KIRKLEES METROPOLITAN COUNCIL INVESTMENT & REGENERATION SERVICE

DELEGATED DECISION TO DETERMINE PLANNING APPLICATIONS

Reference No:	2023/62/92714/W
Site Address:	7, Smithy Way, Lindley, Huddersfield, HD3 3ZD
Description:	Erection of single storey side and rear extensions
Recommending Officer:	Joanna Rednall

HOUSEHOLDER DELEGATED REPORT

client	CHRIS ROWBOTTOM		
project	PROPOSED EXTENSION TO 7 SMITHY WAY LINDLEY HUDDERSFIELD, HD3 3ZD		
drawing	PROPOSED PLANS		
revision	notes	date	drawn
*	*	*	*
scale :	1:50 AND 1:100 AT A1	05.22	PB
project no.	drawing no.	revision	
2001	02

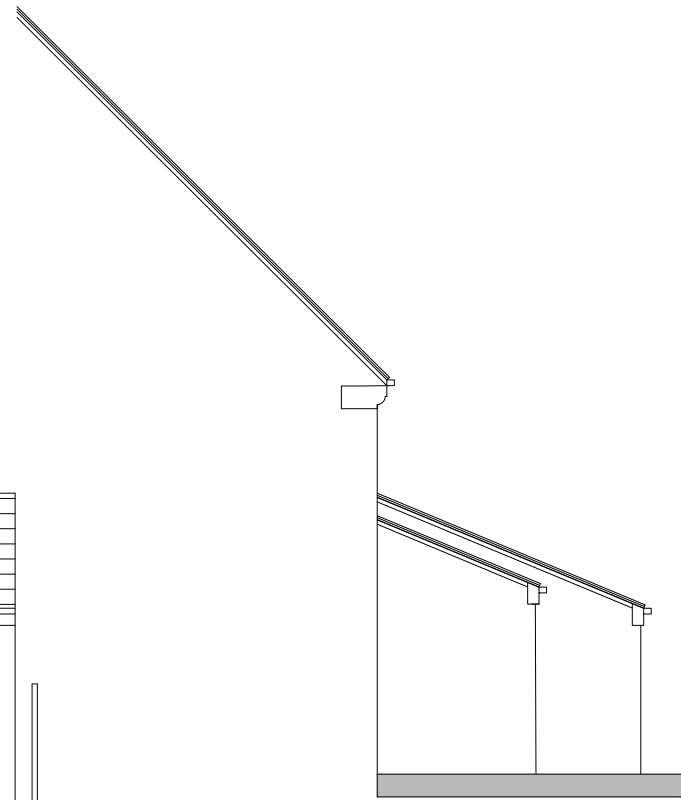
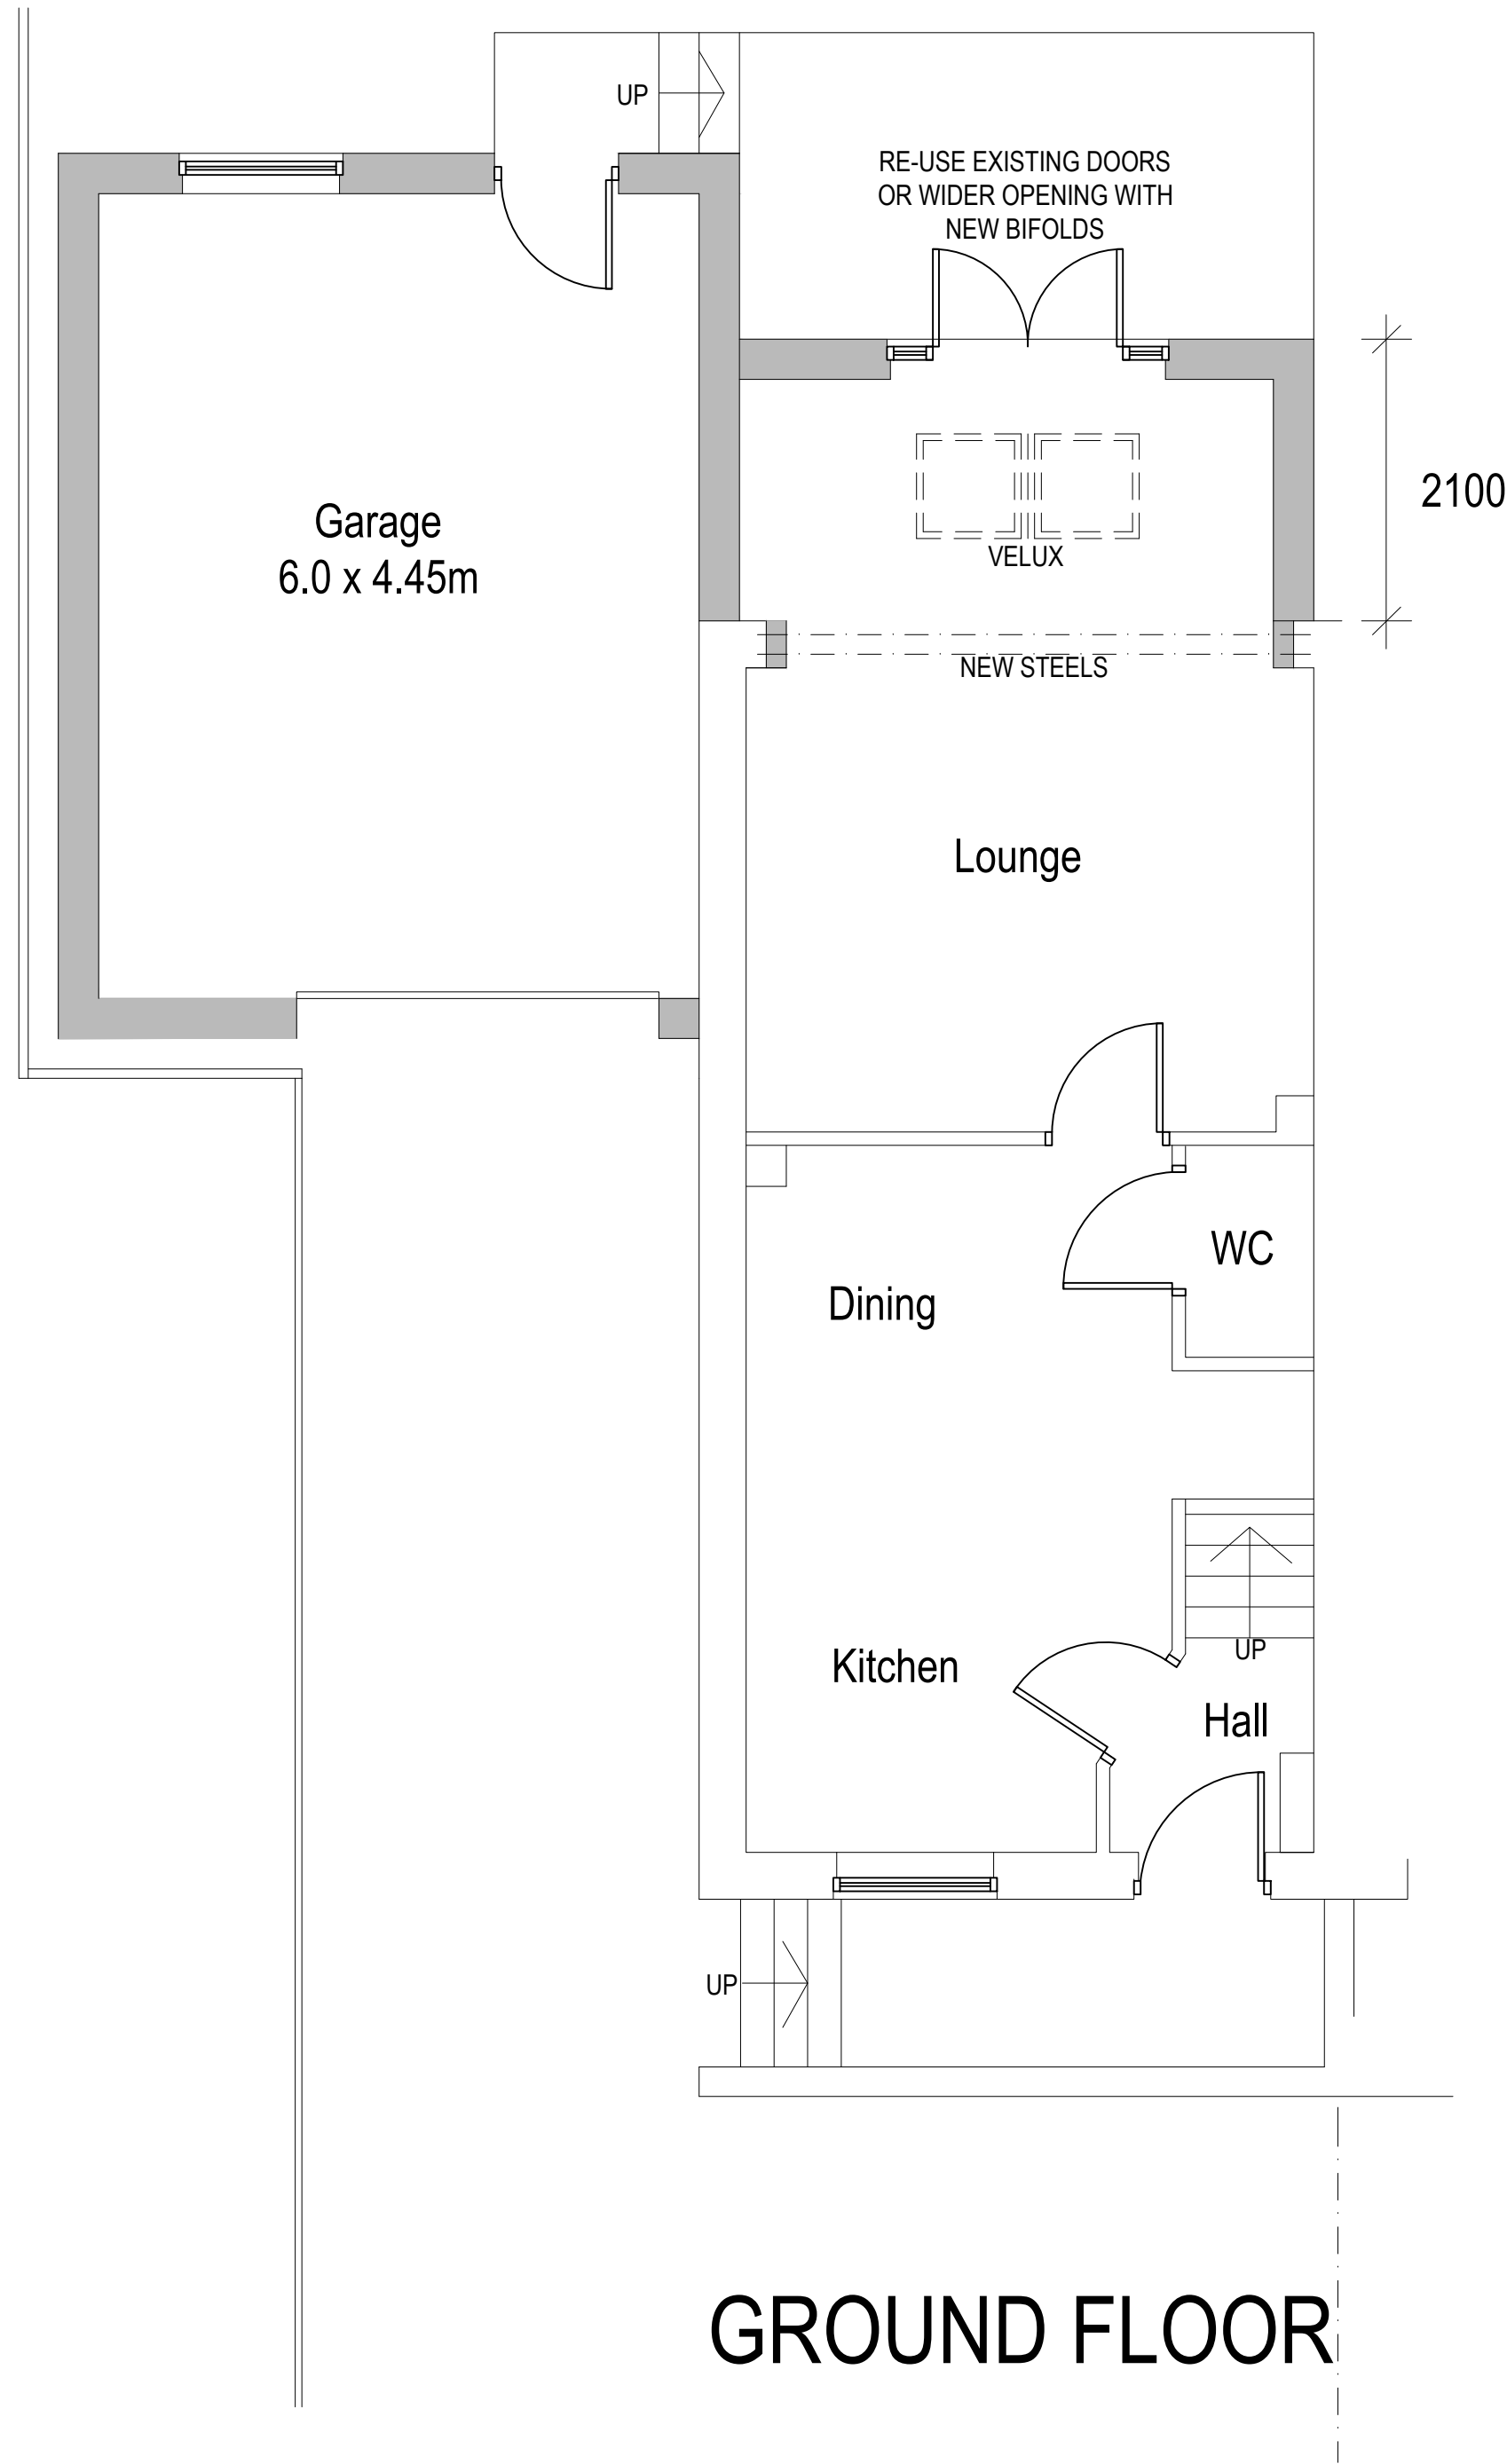
The application seeks permission for the erection of a single storey side and rear extension. The side extension projects ~ 4.8 metres from the south facing elevation and extends ~ 6.5 metres along the property. It would be set back approximately ~3.2 metres from the front elevation of the property. The rear extension projects ~ 2.1 metres from rear elevation and extends ~ 2.3 metres along the rear elevation. The proposed side extension would project ~1.4 metres further than the rear extension. The side extension would have one window on the west-facing elevation overlooking the rear garden, as well as a door. The rear extension would be served by patio doors as well as two rooflights.

The height of the eaves on the side extension would be ~1.4 metres reaching a total height of ~2.1 metres to the ridge of the roof. The eaves height on the rear extension would be ~1.3 metres and reach an overall height of ~1.7 metres to the ridge of the lean-to roof.

Side extensions should:	<u>Yes - COMPLY</u>	<u>No - JUSTIFY</u>
Ensure reasonable levels of natural light to the habitable rooms in neighbouring properties	Yes – the rear extension projects 2.1 metres so is SPD compliant, and it is likely only the proposed roof would be visible from the attached neighbour due to the existing fence.	
Positioning windows to minimise or avoid any potential overlook into neighbouring gardens	Yes – there are no windows on the extension which would overlook neighbouring properties	
Single storey side extensions should:		
Not extend more than two thirds of the width of the original house		No – the side extension projects ~4.7 metres, and the width of the host property is 4.6 metres wide. Approximately ~0.9 metres of the proposed side garage would be screened by existing boundary fence. In addition the development is set well back from the front elevation of the host property, and predominantly located in the rear amenity space. As such it is considered the proposal would be acceptable in

semidetached and terrace houses or by 4 metres for detached properties		
Where they exceed 3m in length the eaves height should generally not exceed 2.5 metres	The proposal does not exceed 3 metres in length	
Retain a gap of at least 1 metre from a property boundary, such as a wall, fence or hedge		No – the extensions would leave ~0.2 metres between the boundaries however, in this case, this is concluded to be acceptable given the justifications put forward and the fact rear access would be able to be taken through the garage.

Relevant key design principle (KDP) of the SPD, Policy in the Kirklees Local Plan and the NPPF	Further comments	✓ / X / N/A
Impact on the Local character and street scene	• KDP1 of the SPD • Policy LP24 Design (a) and (c) of the KLP • Chapter 12 NPPF	Rear extension has a total projection of ~ 3.4 metres and would not be visible from public vantage points as there are existing dwellings surrounding the property. Side extension extends ~ 4.7 however would be screened from the front	✓

Window proportions	• KDP 1 and 2 of the SPD • Policy LP24 Design (a), (c) and (d) of the KLP • Chapter 12 of the NPPF	Full length opening within the rear elevation – existing doors moved forward ~ 2.1 metres overlooking rear garden. No windows on side elevations – avoiding potential overlook on neighbouring properties.	✓
Accessibility for all users	• KDP 17 of the SPD • Policy LP24 Design (f) • Chapter 12 of the NPPF	Private domestic extension – no alterations to general access arrangements.	✓
